Appeal Decision

Appeal Ref: APP/C3810/W/18/3209225

Land at Arundel Road/A27 Angmering, BN16 4EU

- The appeal is made under section 78 of the Town and Country Planning Act 1990 against a refusal to grant planning permission.
 - The appeal is made by Mr Benjamin Burrell against the decision of Arun District Council.
 - The application Ref A/3/18/PL, dated 7 June 2017, was refused by notice dated 27 July 2018.
 - The development proposed is for '*Change of use of land to storage (B8 Storage or distribution), Erection of barn and hardstanding*'.
-

1711056-SK01

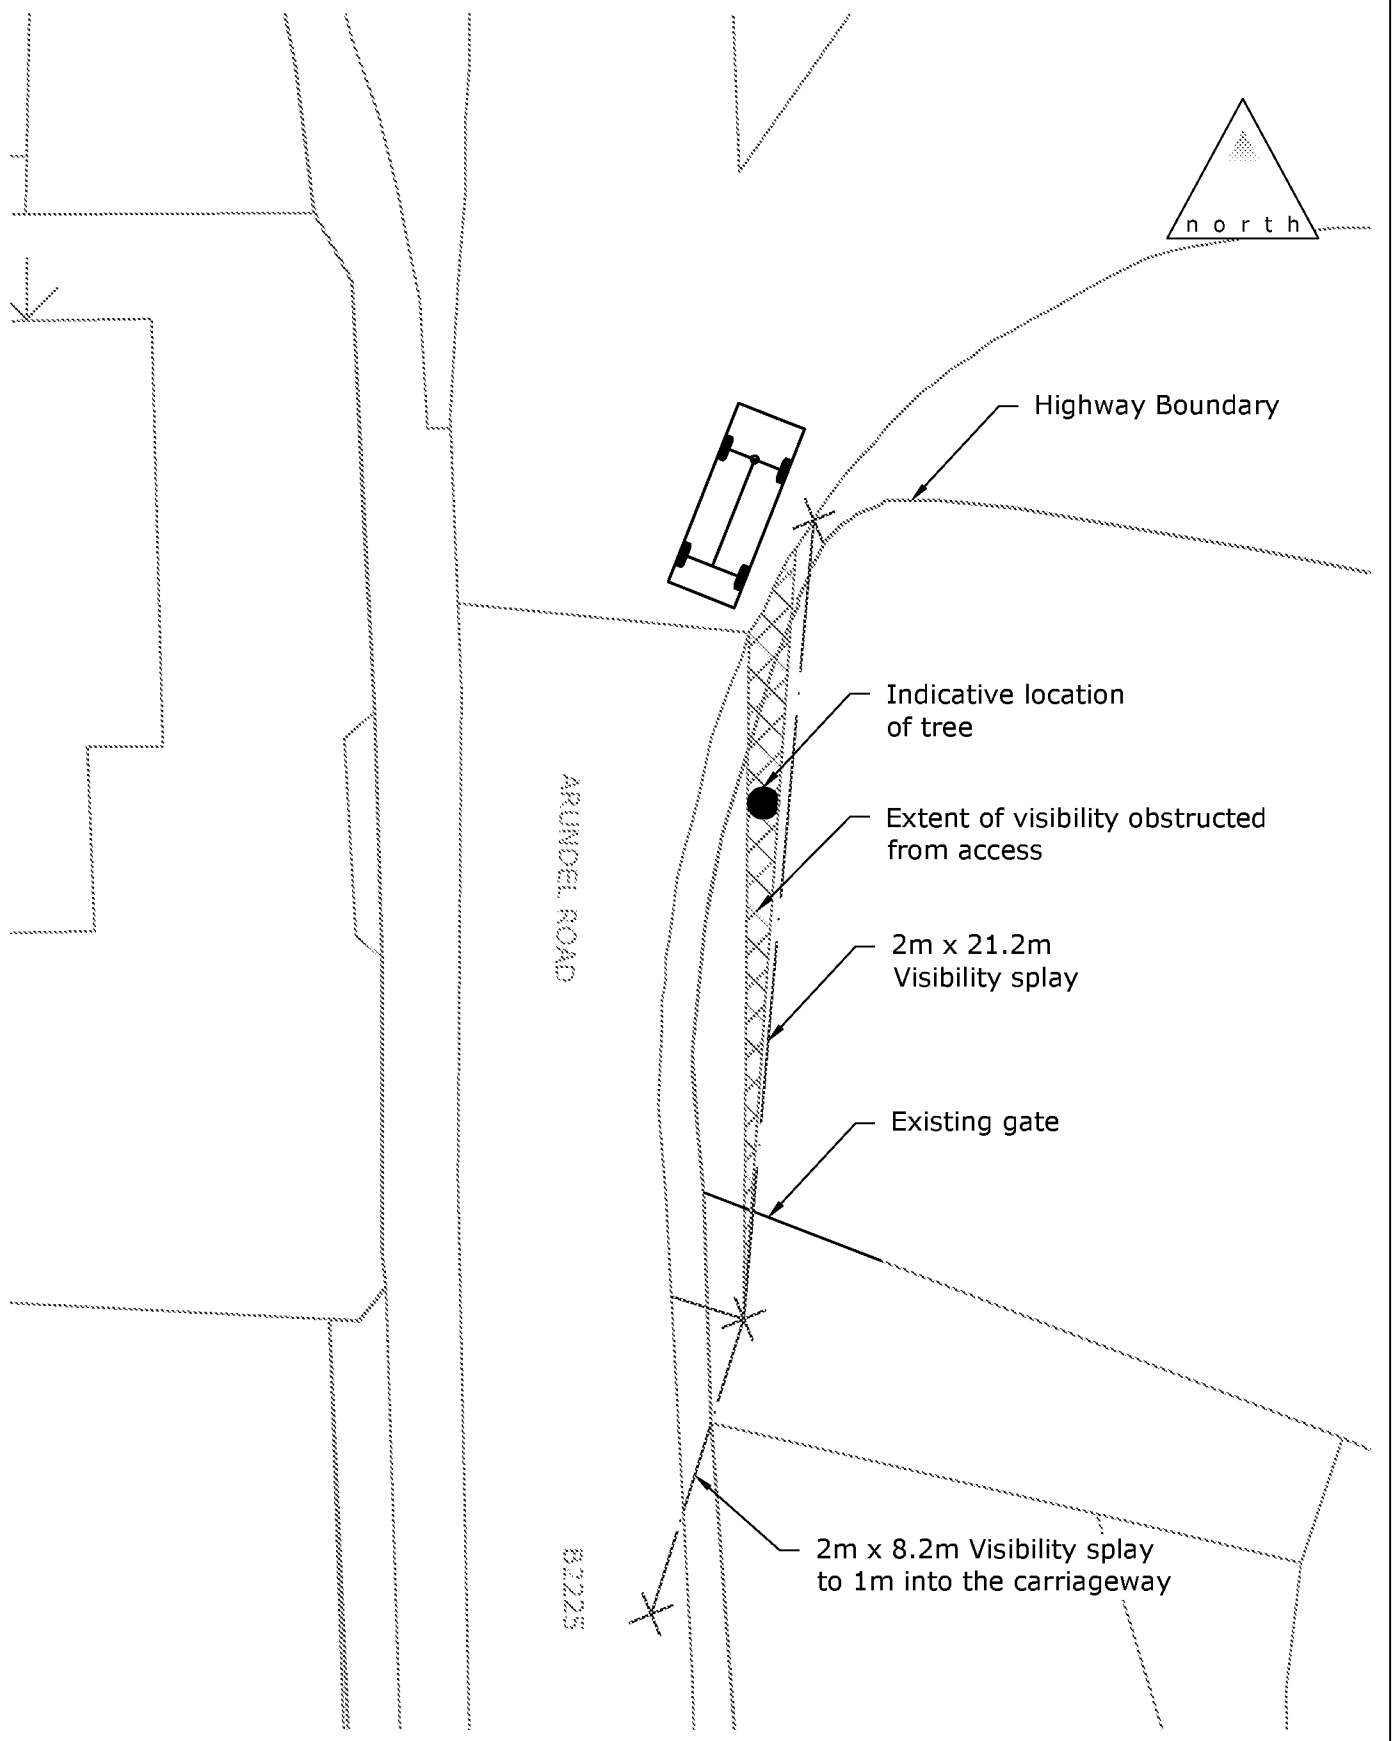
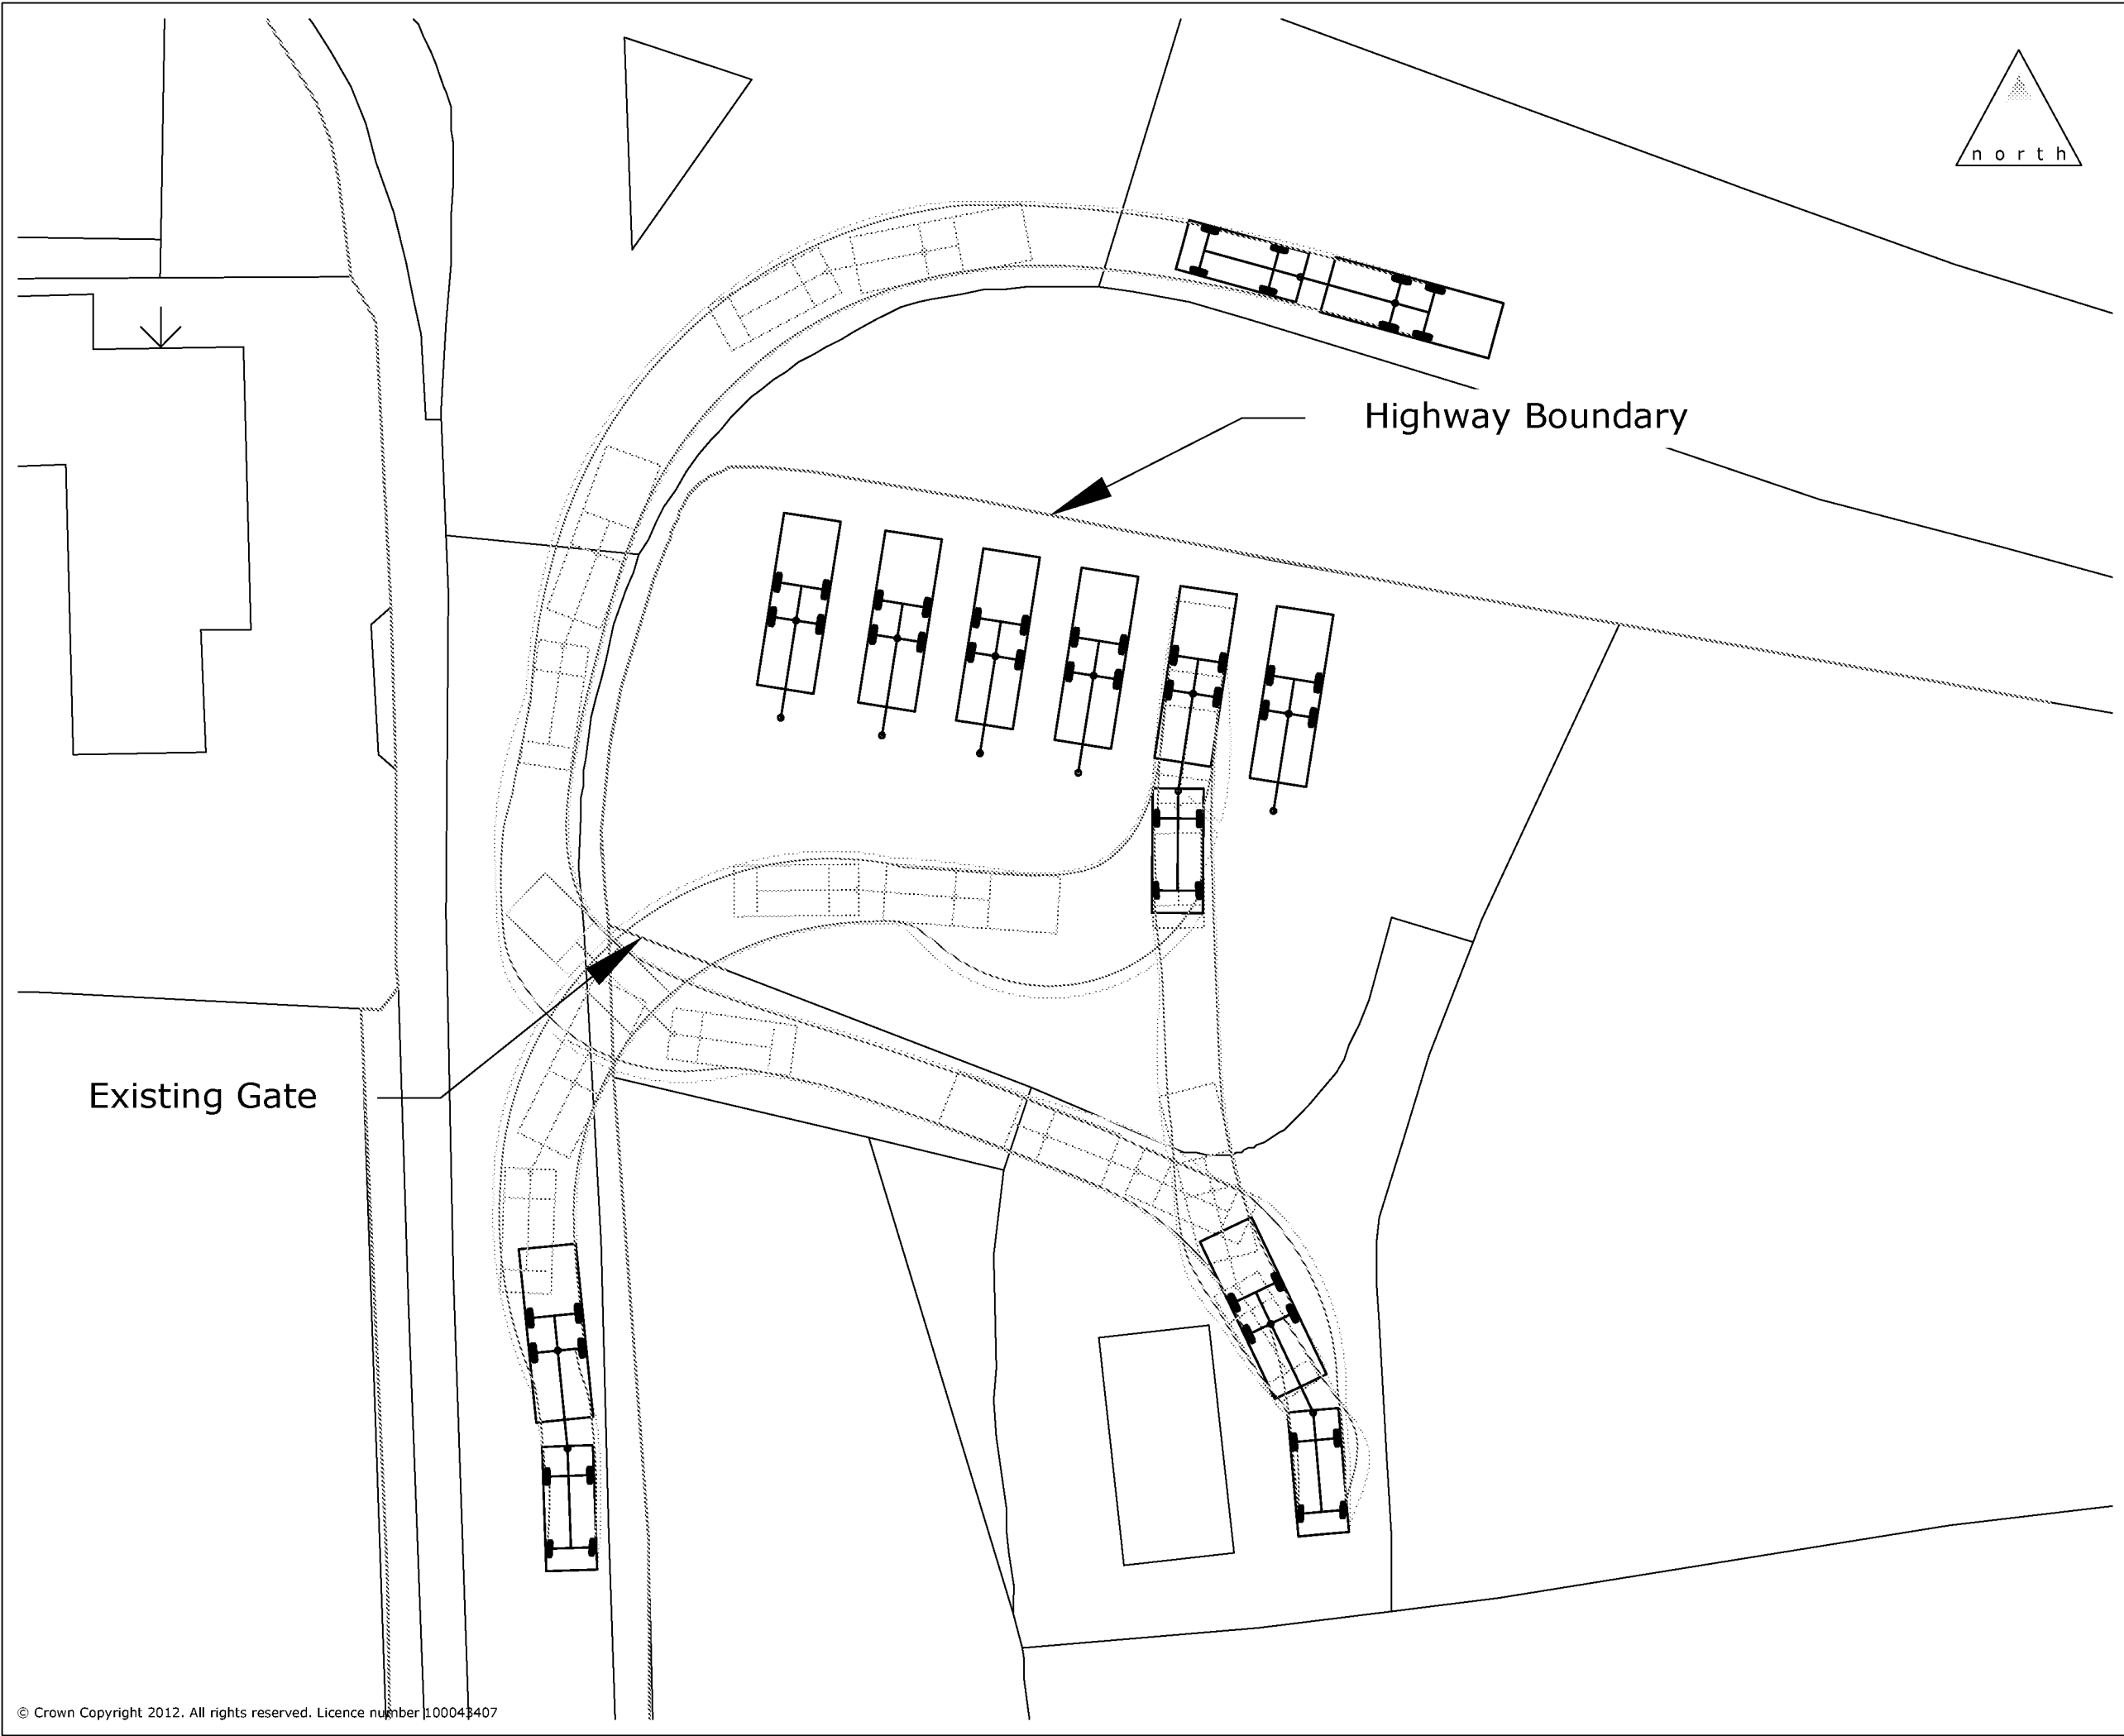
9. However, to the south the submitted visibility plan shows a splay of 2m x 8.2m. If one were to take the visibility splays from MfS, northbound vehicular speeds on Arundel Road would need to be in the region of 10mph for this distance to be acceptable. There is no data in the appellant's transport statement regarding northbound speeds or volumes which is surprising given that paragraph 4.8 categorically states that the Highway Authority's only remaining concern is visibility to the south. Based on the horizontal alignment of Arundel Road and my own observations and notwithstanding that vehicles might be slowing down on the approach to the A27 junction, I consider that northbound speeds are considerably higher than 10mph. The Council has commented that 'observed speeds are low past the site'. However, without a speed survey that proposition is nothing more than an assertion.

11. I have noted the appellant's reliance on paragraph 10.5.9 of the MfS. However, the starting point is that Y distance should be based on the recommended SSD values. That is not the case here, nor is there any 'local evidence' before me to demonstrate that a shortfall of the magnitude proposed would not lead to a significant problem.
